DESIGN PROFESSIONAL INSPECTION FORM

DATE INSPECTED: 4/18/2025
PROJECT NO.: 29WN0001
PROJECT NAME: Maple Drive Lots 2-3 Drainage
PERMIT NO. SFD2503-0039
PROJECT ADDRESS: 141 MAPLE DR., ERWIN, NC
PROJECT COUNTY: Harnett
OWNER: WELLONS REALTY
CONTRACTOR: WELLONS REALTY
INSPECTOR: Joe Godwin joe@godwinengineering.com
ENGINEER: Joe E. Godwin, Jr., PE joe@godwinengineering.com
COMPONENT/ELEMENT: FOOTING
APPLICABLE CODE: ☐ 2018 NC Building Code (NCBC 2018)
☒ 2018 NC Residential Code (NCRC 2018)
☐ 2018 Existing Building Code (NCEBC 2018)

PIER and CURTAIN FND.
FOUNDATION PLAN
SCALE: 1/4" = 1'-0"

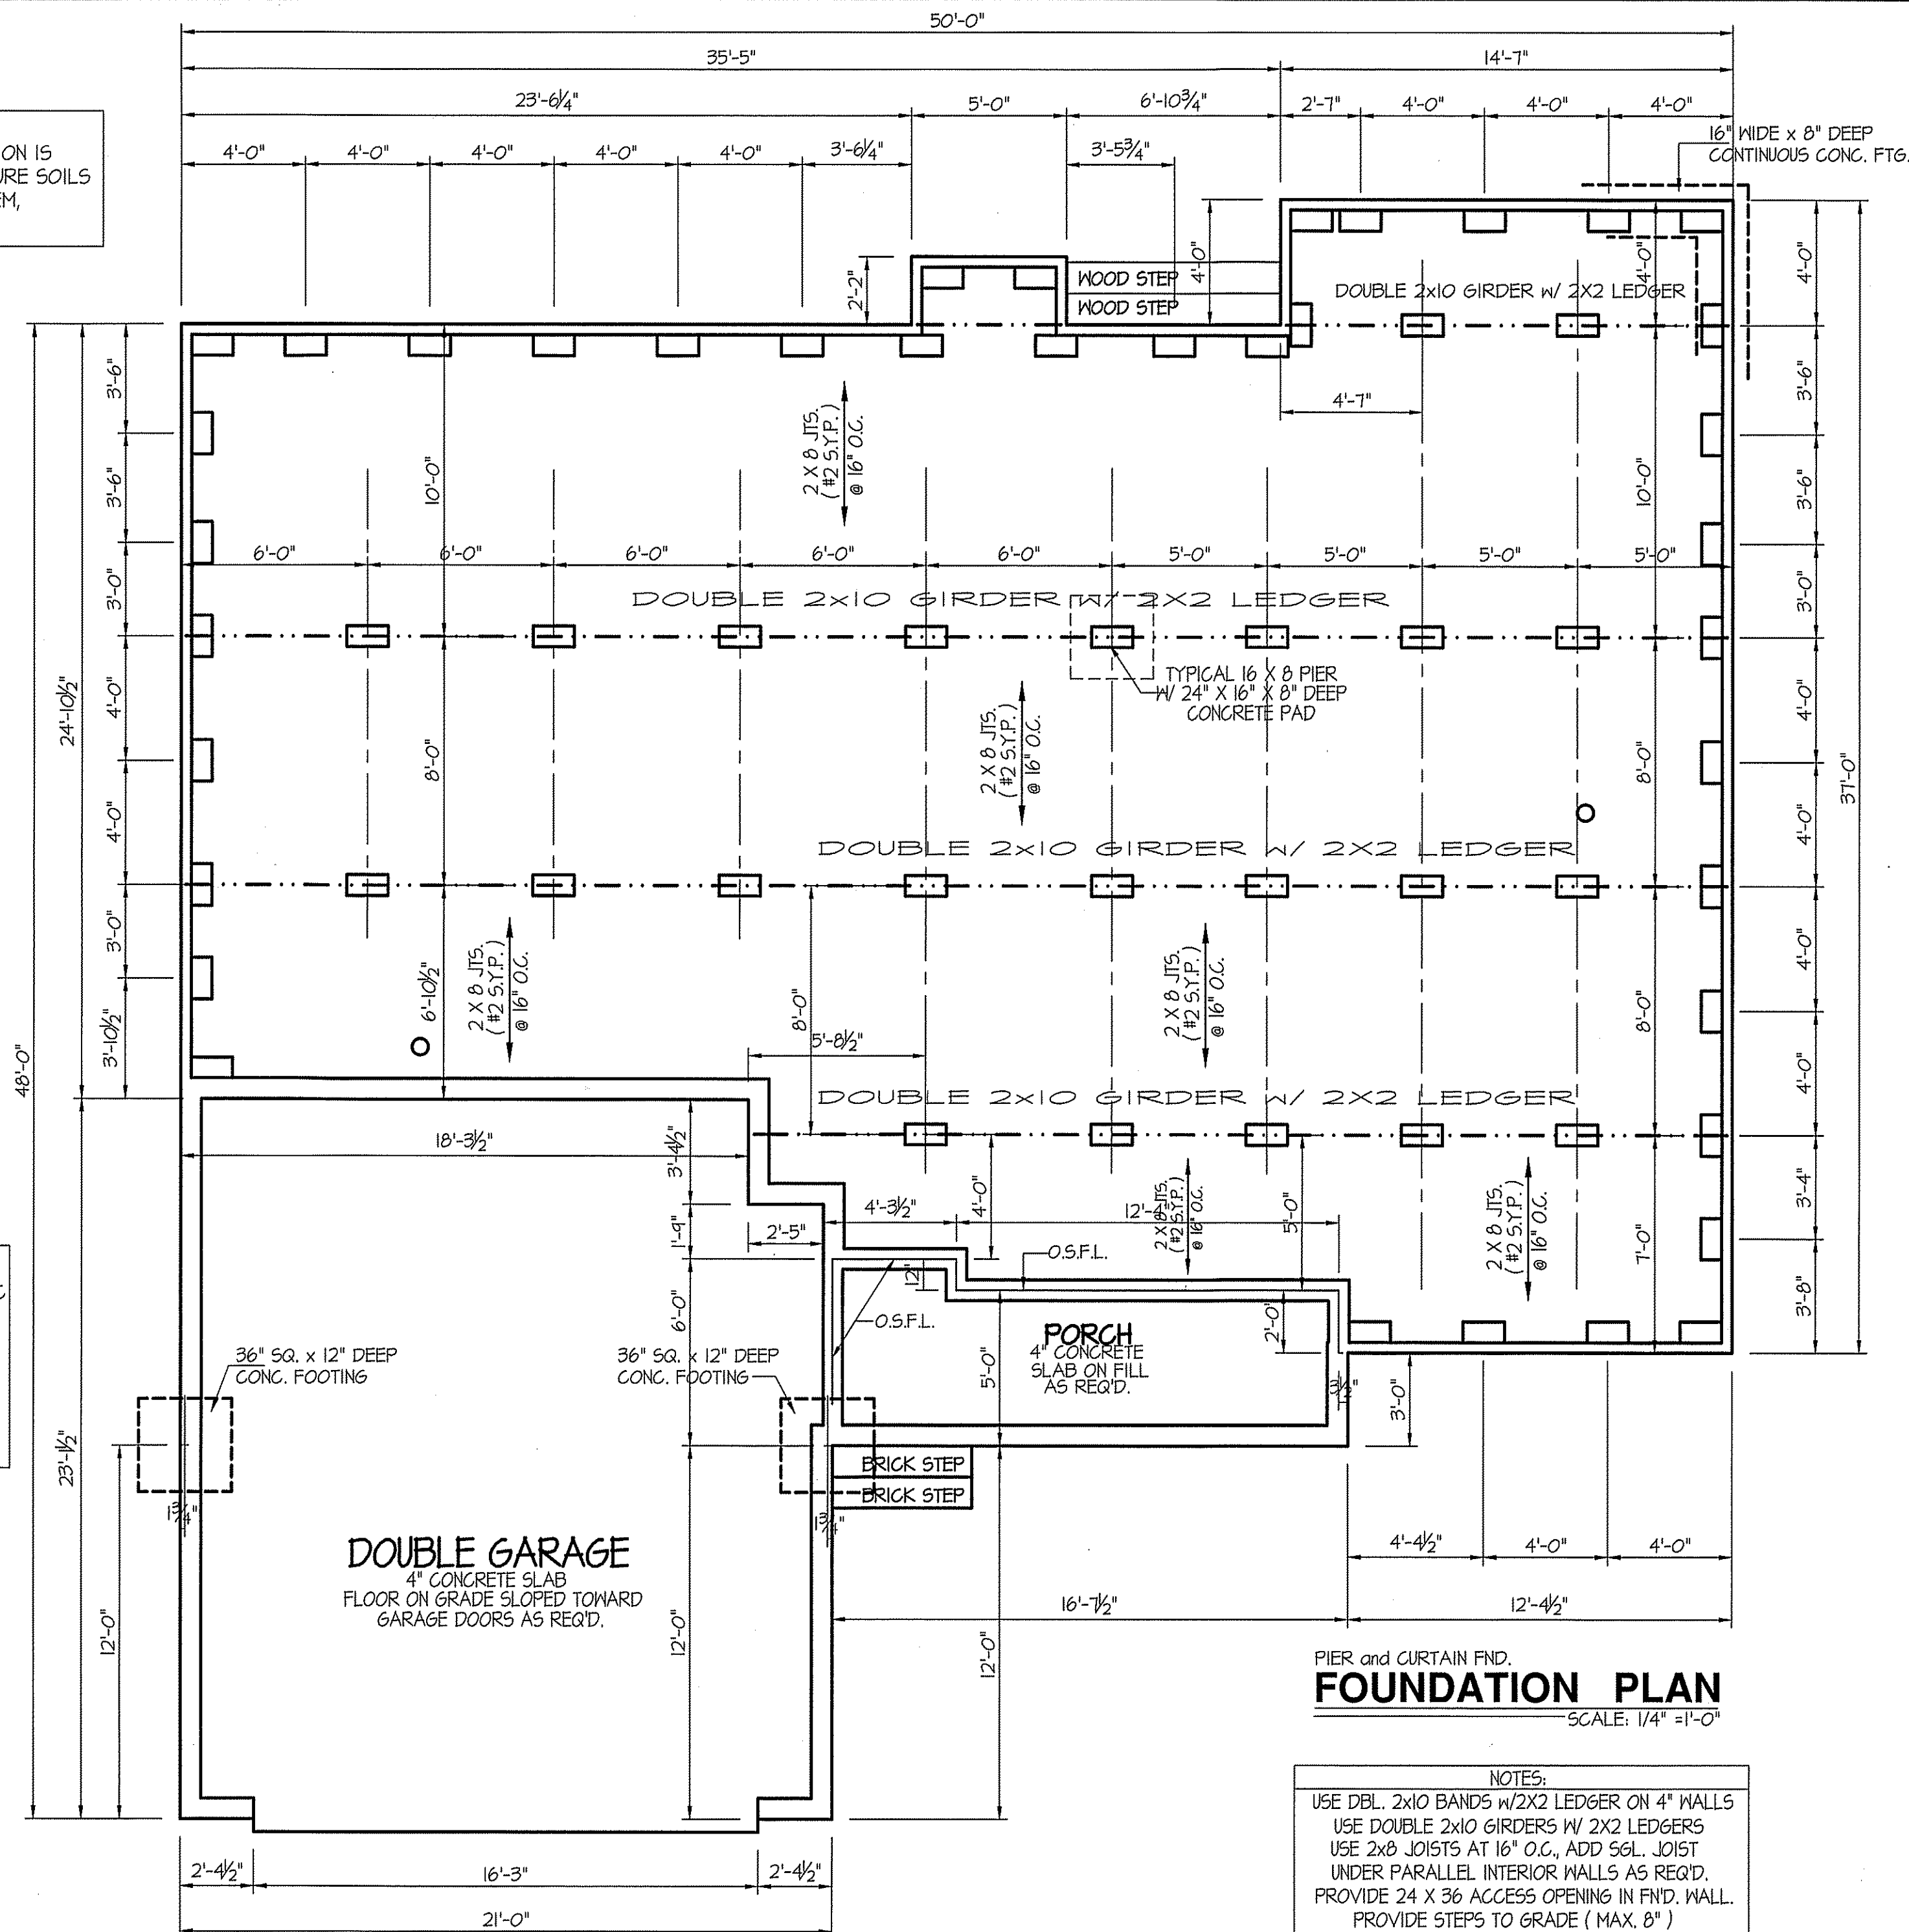
Inspected footing for lot#2. All footings meet or exceed minimum bearing capacity with exception of 2 spread footings at columns in garage. Recommend removing 12" depth of subsoil in square footings located at the garage, and backfilling with uniformly graded stone (e.g. #57, #5, etc.). No re-inspection required.
